From: webmaster@ribblevalley.gov.uk <webmaster@ribblevalley.gov.uk>
Sent: 23 February 2021 08:59
To: Planning <planning@ribblevalley.gov.uk>
Subject: Form completion: Planning Application Comments Form

title: 
LastName: 
firstName: 
numberName: 
postAddress: 
postCode: 
refNo: 3/2021/0082
addDev: 24 Blakewater Road Clitheroe Lancashire BB72FT

Dear Sir/Madam, We would like to formally object to the planning request for the extension to 24 Blakewater Road, Clitheroe, BB7 2FT.

proposed rear  
(NE facing) elevation

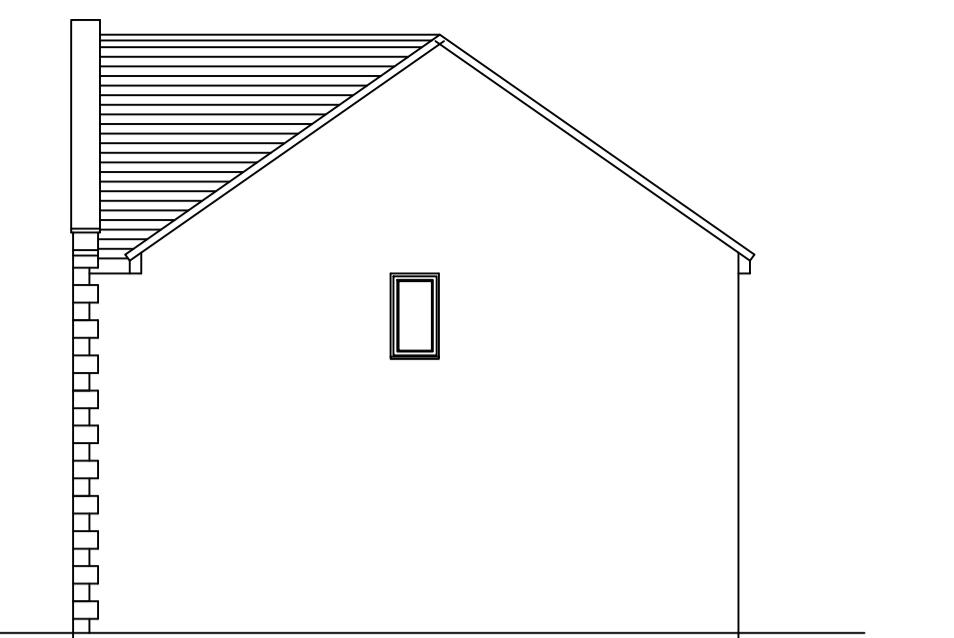
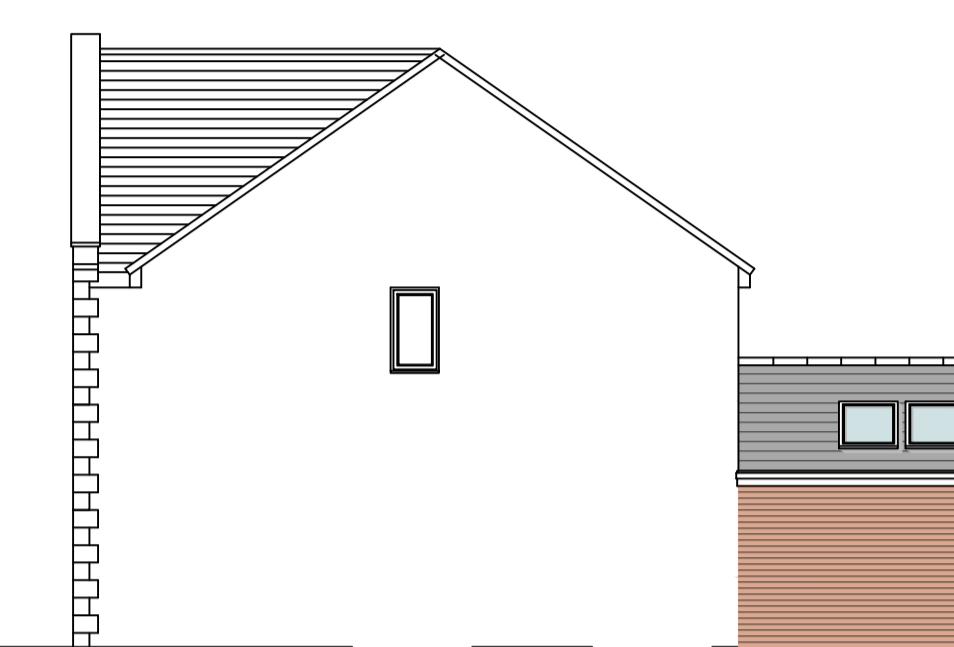
This extension would cover the width of our garden and some of no. 3 Lune Road. Our garden fence is c2m high and the proposed extension is 4m high. Our garden is small and this issue is most likely different to most other designs on the estate, in the fact 24 Blakewater is side on to the end of my small garden, thus making the extension inappropriate as this is much closer to my garden than I expect would be the normal case. The build extension itself appears to lead from the side walls ending 2.2m high to a 4m high point of the roof. Nearby extensions all seem to have a small sloping roof that would be much less in height. This design doesn't fit within the close homes that have or are having extensions with much smaller roofs (flat or small sloping) (namely numbers 26, 14 & 12 Blakewater Road and 11 Lune Road - all within close proximity of this proposed development) and has an effect on the character of the neighbourhood as a result there is just no need to have such a large roof. The design itself looks like this would massively increase the light within 24 blakewater and at the same time, reduce the natural light to our home and cause overshadowing. This leads to an adverse impact on the residential amenity of our property and creates a sense of enclosure boxing us in. The proposed extension would significantly reduce our current view leading to less natural light coming into the dining room, kitchen and 2 upstairs bedrooms. The visual impact is adversely so great, we would never have purchased this house if that extension was built. The loss in outlook would be a

significant point â€“ the extension of that height would have an overbearing effect resulting in an unduly oppressive living environment for ourselves and/or future residents. I also note, that there are 2 windows in the roof of the proposed extension that look directly into our kitchen/dining area thus impacting on our privacy. Overall, to summarise, the approval of the extension would: - Have a significant visual impact on our property. - Effect the character of the neighbourhood with the large roof that could be much less in height. - Have an adverse impact on the residential amenity of our property as a result of losing natural light into our dining room and kitchen mainly. - Overshadowing/sense of enclosure boxing us in. - Loss of outlook and loss of view leading to an overbearing effect resulting in an unduly oppressive living environment. - loss of privacy I would appreciate you considering all of the above and bear in mind that this proposal is very close to the rear of our fence. Had 24 Blakewater Road had a back garden that lead length ways directly to our garden length ways in which we already see a building, then this wouldnâ€™t make much a difference. Again, I cannot understand why the roof needs to be that high without the having a detrimental effect on ourselves to the benefit of 24 Blakewater Road. Many Thanks
